**Re: Planning application number: 3/2020/ 1015**

We have the following comments about planning application number **3/2020/1015** - to erect a single story detached two-bedroom house at the end of the rear garden of Inglemead, Waddington Road, Clitheroe BB7 2HN with access from Hawthorne Place.

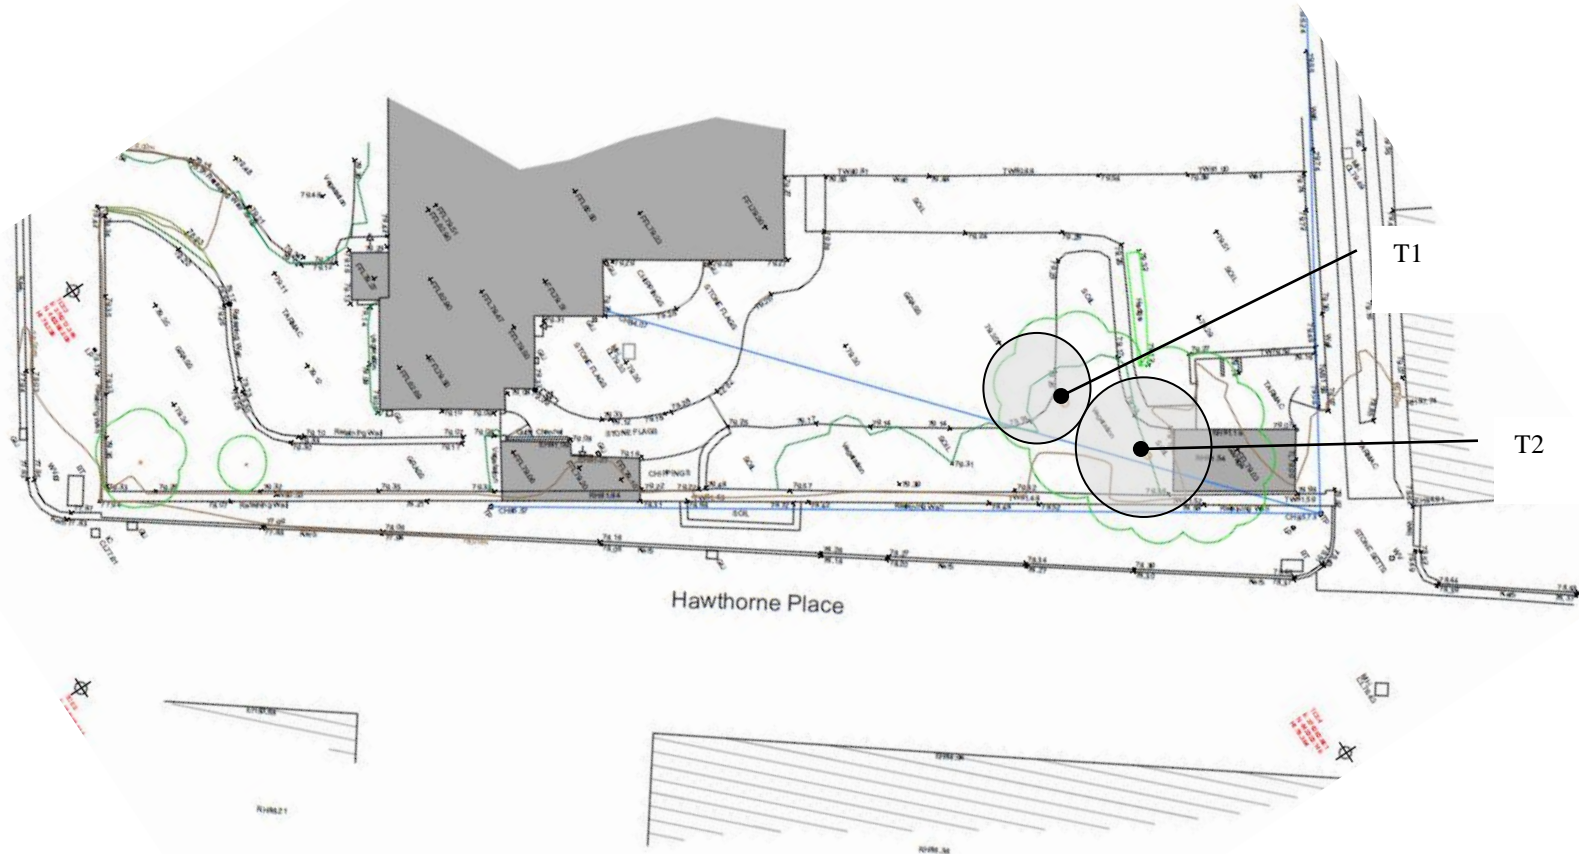
The design and access statement section 1.1 suggests that the house would be built on a 'relatively level disused area of garden'. We would like to point out that prior to the applicant's recent purchase of Inglemead, this was a productive fruit and vegetable garden which was a source of visual amenity from upstairs windows of surrounding properties and whose residents benefitted from its produce. This is also the case with the apple tree which is at least 30 years old and continues to be very productive.

Drawing No. A209 Revision

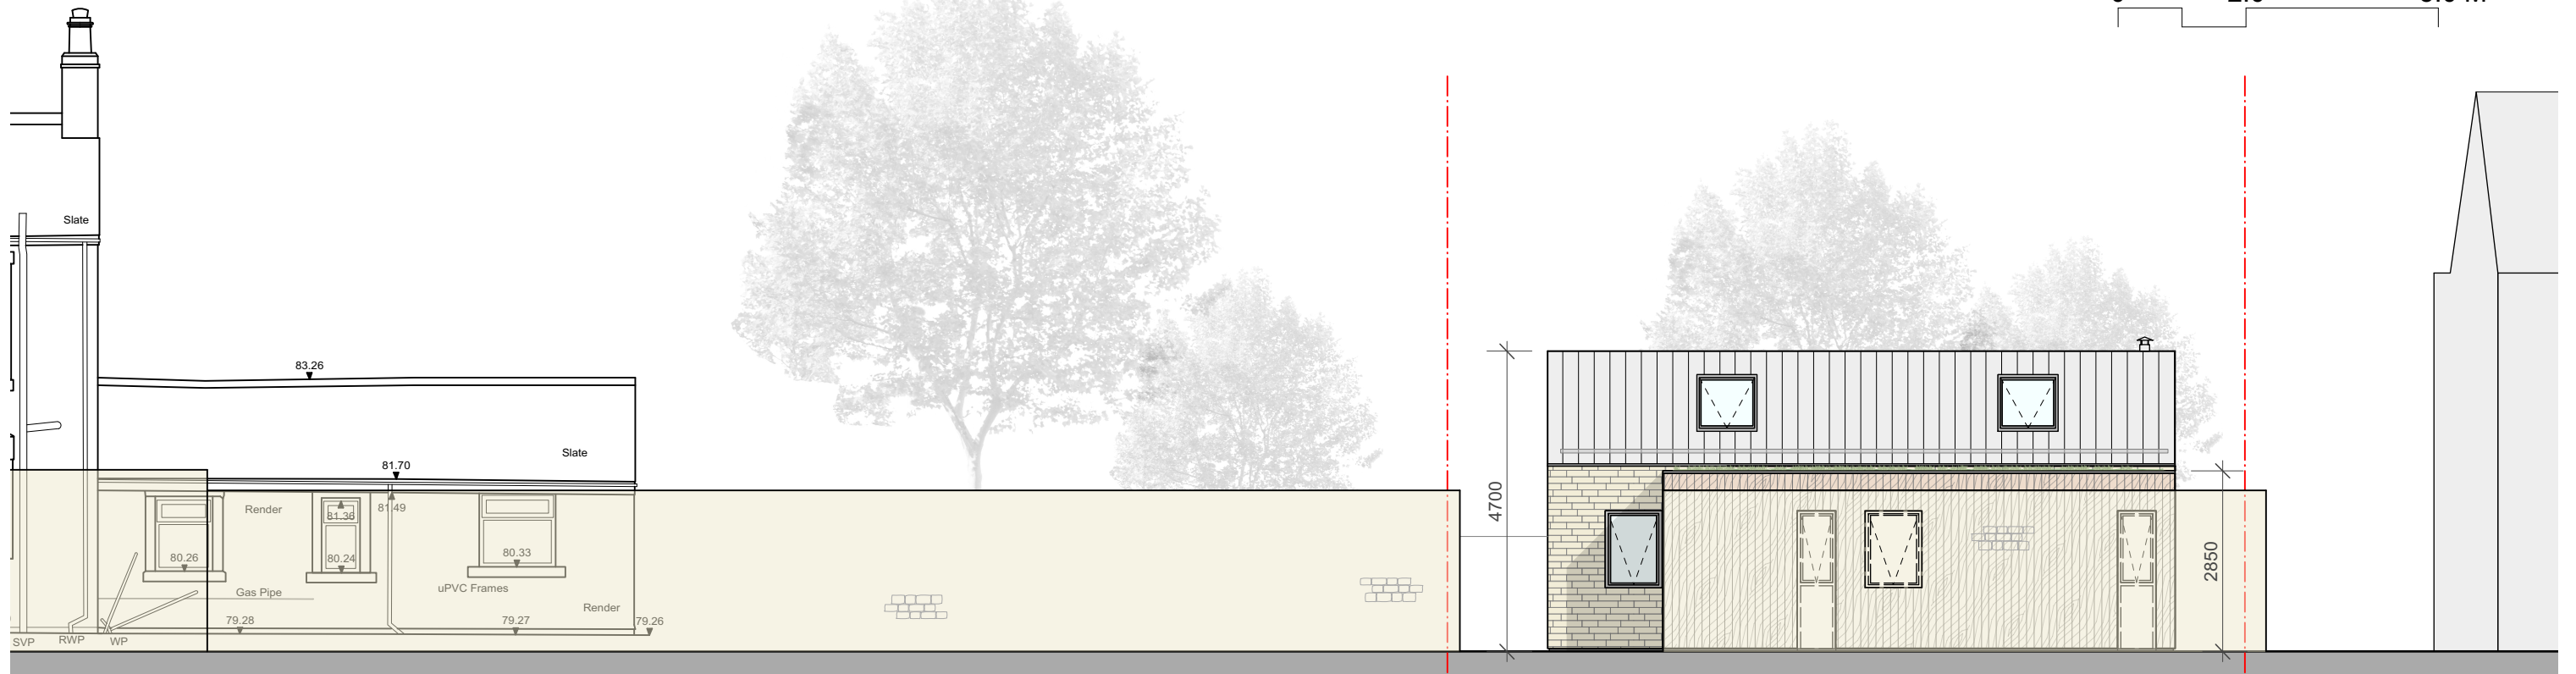
Although we appreciate that the applicant may be wishing to use mixed materials for the building as a feature, this is not in keeping with surrounding dwellings which are in a traditional style. We would suggest all the building is of coursed stone.

Whilst we appreciate the ecological benefits of the flat sedum roof and the fact that this is low and expected to be hidden behind the higher wall, again this is not in keeping with surrounding property styles and would appear more in keeping if it has a slightly pitched roof in slate. The sedum roof is a minor gesture compared to the loss of flora and fauna caused by building's erection.

The zinc type roof (grey standing- seamsheet metal) is not at all in keeping with surrounding properties or Inglemead and would stand out as such. The roof should be made of slate.

The height of the rear gable part of the building appears to be unnecessarily high for a single storey building. We are concerned that an unusually high single storey building (over 4.2m) could later be converted to 2 storey accommodation. We note that pre application comments from Adam Birkett 2.9.2020 Ref RV/2020/ENQ/00064 suggesting that a single storey building is preferred are not attached as described in the application form. We have requested sight of these comments. However, if this is not possible, we would like assurance that there would be no opportunity to make this into a two-storey building which ultimately would compromise privacy.

If the pitch height of 4.7m could be reduced, which would still maintain appropriate rainwater fall off, the building would be less obtrusive. The design and access statement says that the height is not dissimilar to other single storey structures locally. We would disagree and suggest that the height of the building should not exceed the height of other single storey structures surrounding it. Currently the height shown on the plans does.

As mentioned previously, the height of the pitched part of the building should be reduced and this, then, would fall in line with the height of other pitched rooves on the access service road and will be less intrusive and would also allow more light to surrounding properties' gardens.

Drawing No. A200 Revision

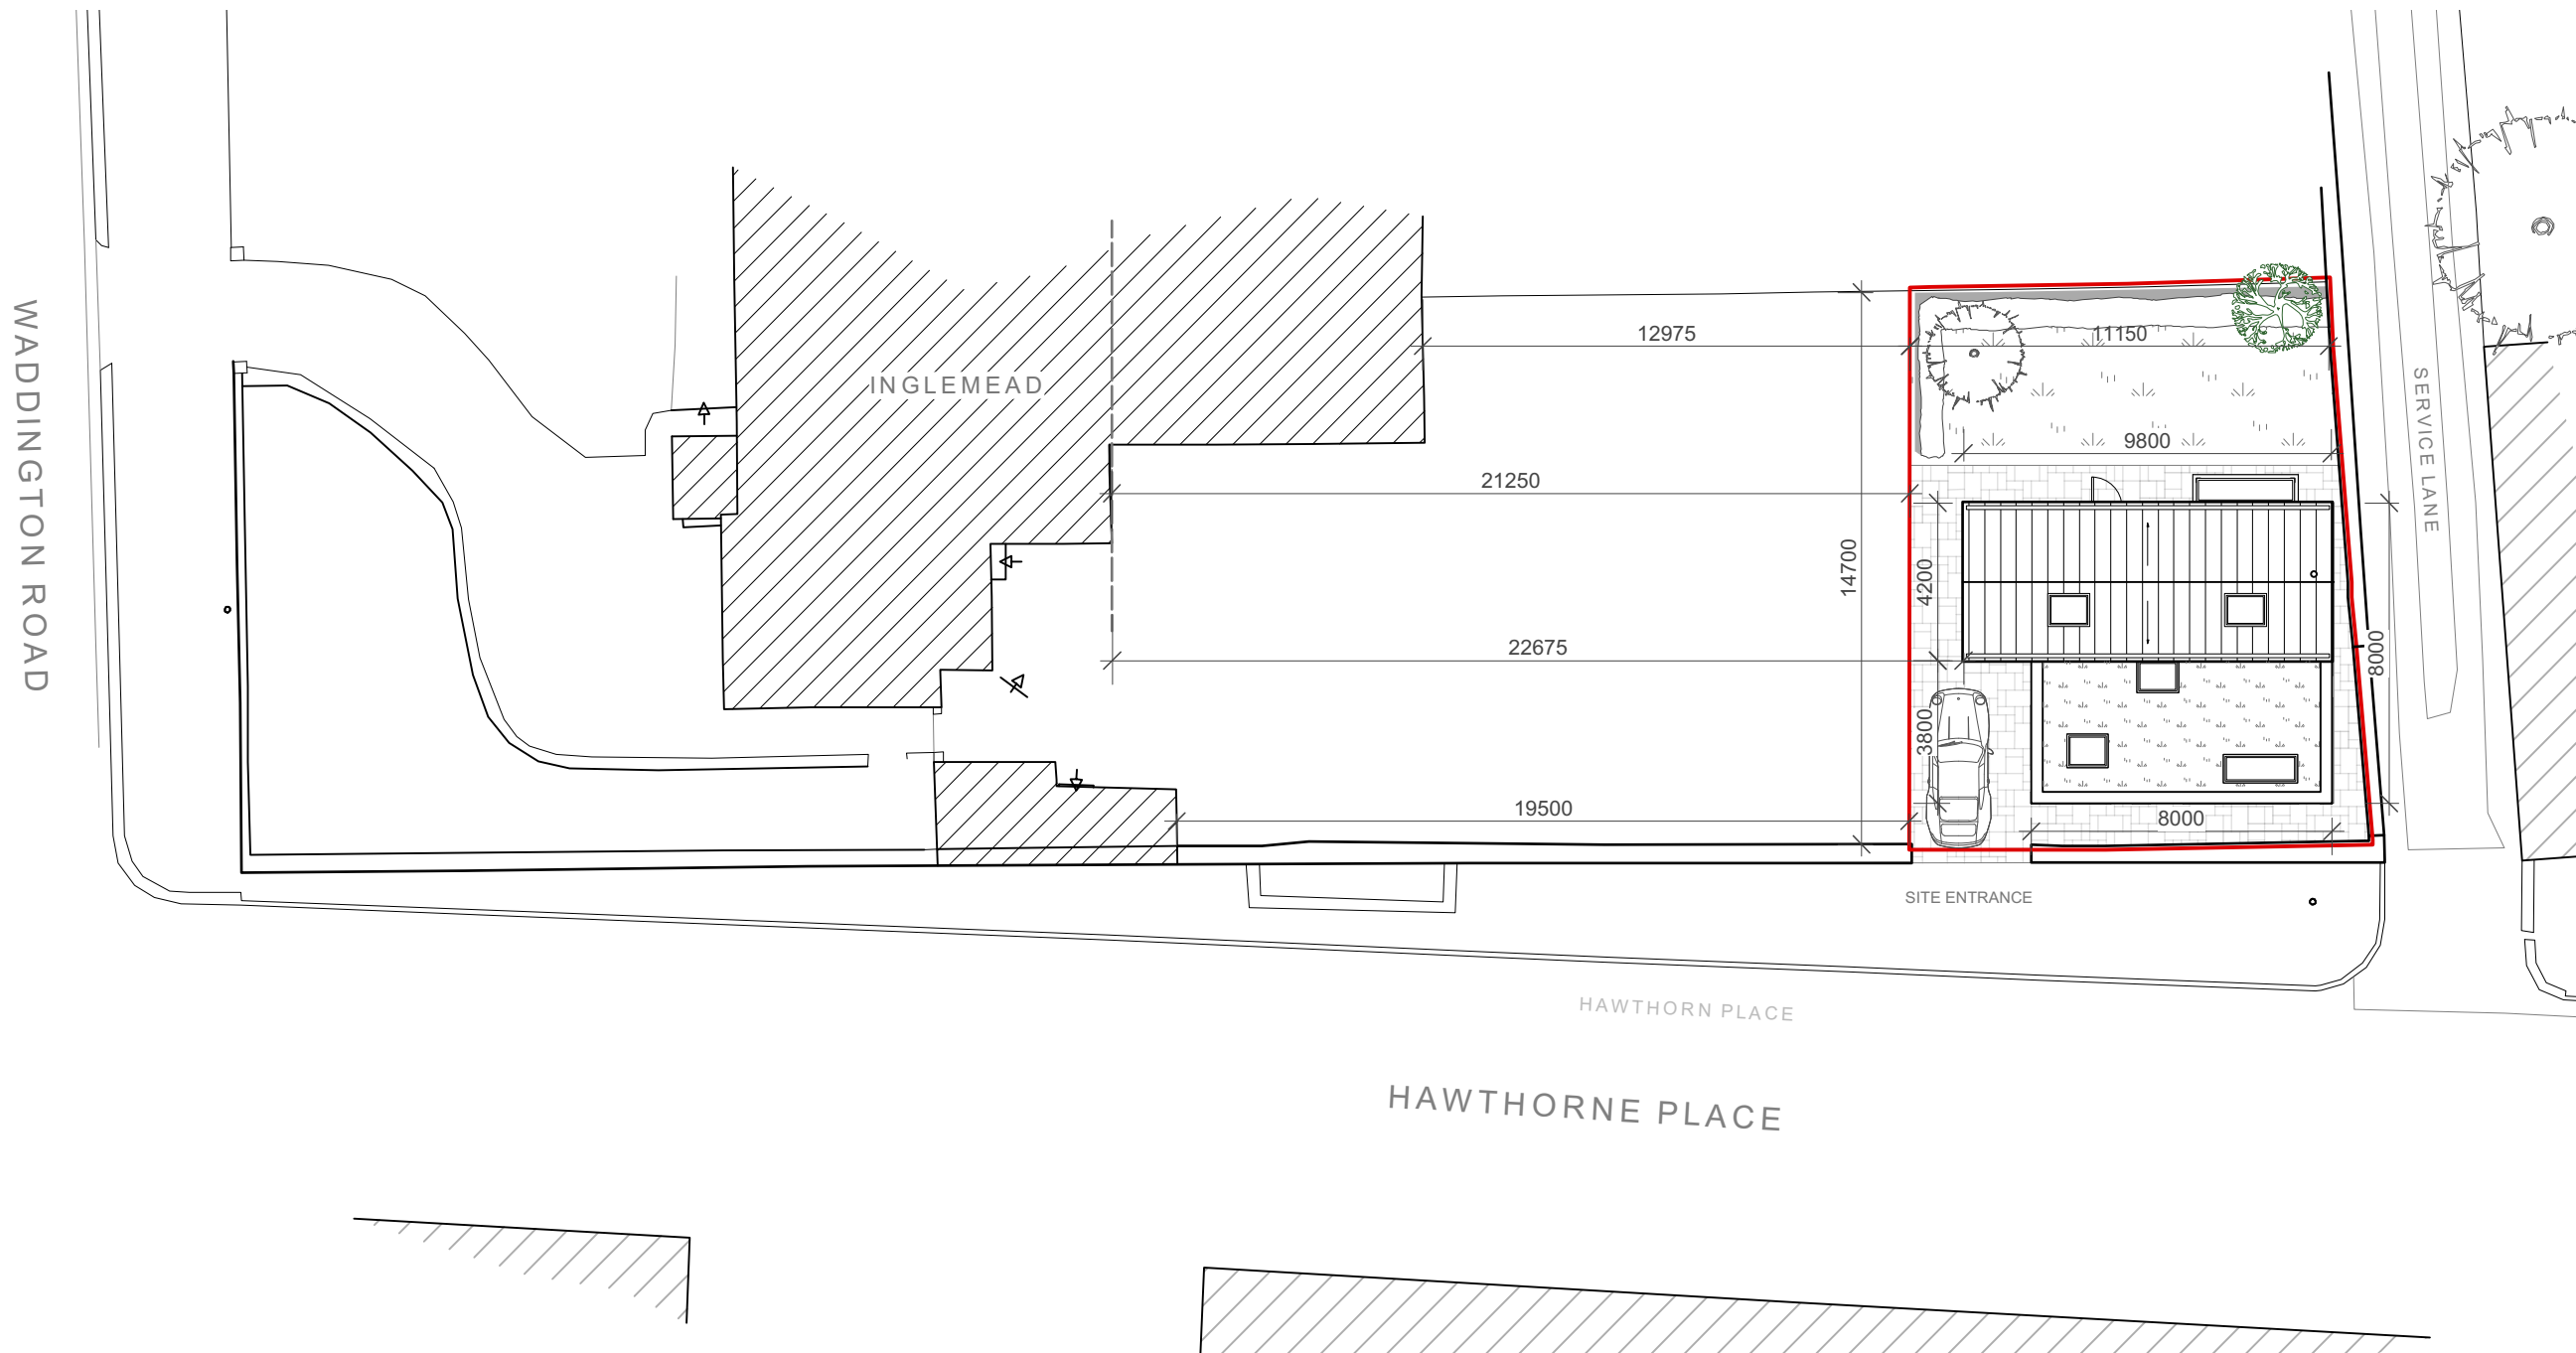
The close boarded long wooden fence dividing the garden from Inglemead is not particularly attractive from any aspect and we would suggest that the walled Victorian garden theme is maintained. If this barrier is to be erected, it should be constructed of coursed or random stone with appropriate planting on either side. A close boarded high fence of 14.7m length would be an unpleasant view from our garden and our upstairs windows and those of neighbouring properties. The height of the fence is not clear in the drawings, but we would need assurance that the fence is of a legally acceptable height. If any hedging is planted, we would ask that it not be coniferous as this, although cheap and fast growing is unsightly and difficult to control in the long term.

from the rear wall of the property to the boundary garden wall. This close proximity together with the height of the building, by calculation will also offer unwelcome shade. The design is unacceptable to the highways at 5m for parking space length at the front of the property and 5.5-6m is recommended which would mean moving the house a further 0.5-1m backwards reducing the rear space even further and encroaching more on privacy and light for the neighbouring property's greenhouse and garden.

Does the site have any existing parking spaces? Will the site add or remove any parking spaces? (Section 9 of application) The answer should be yes. There is parking in the current garage. Residents on Hawthorne Place will see a reduction of on street parking spaces available to them in an already congested parking situation where outside working hours, cars are parked on both sides of the narrow street. This already often results in difficulty accessing the rear service lane to Inglemead, Riversdale and neighbouring properties. The
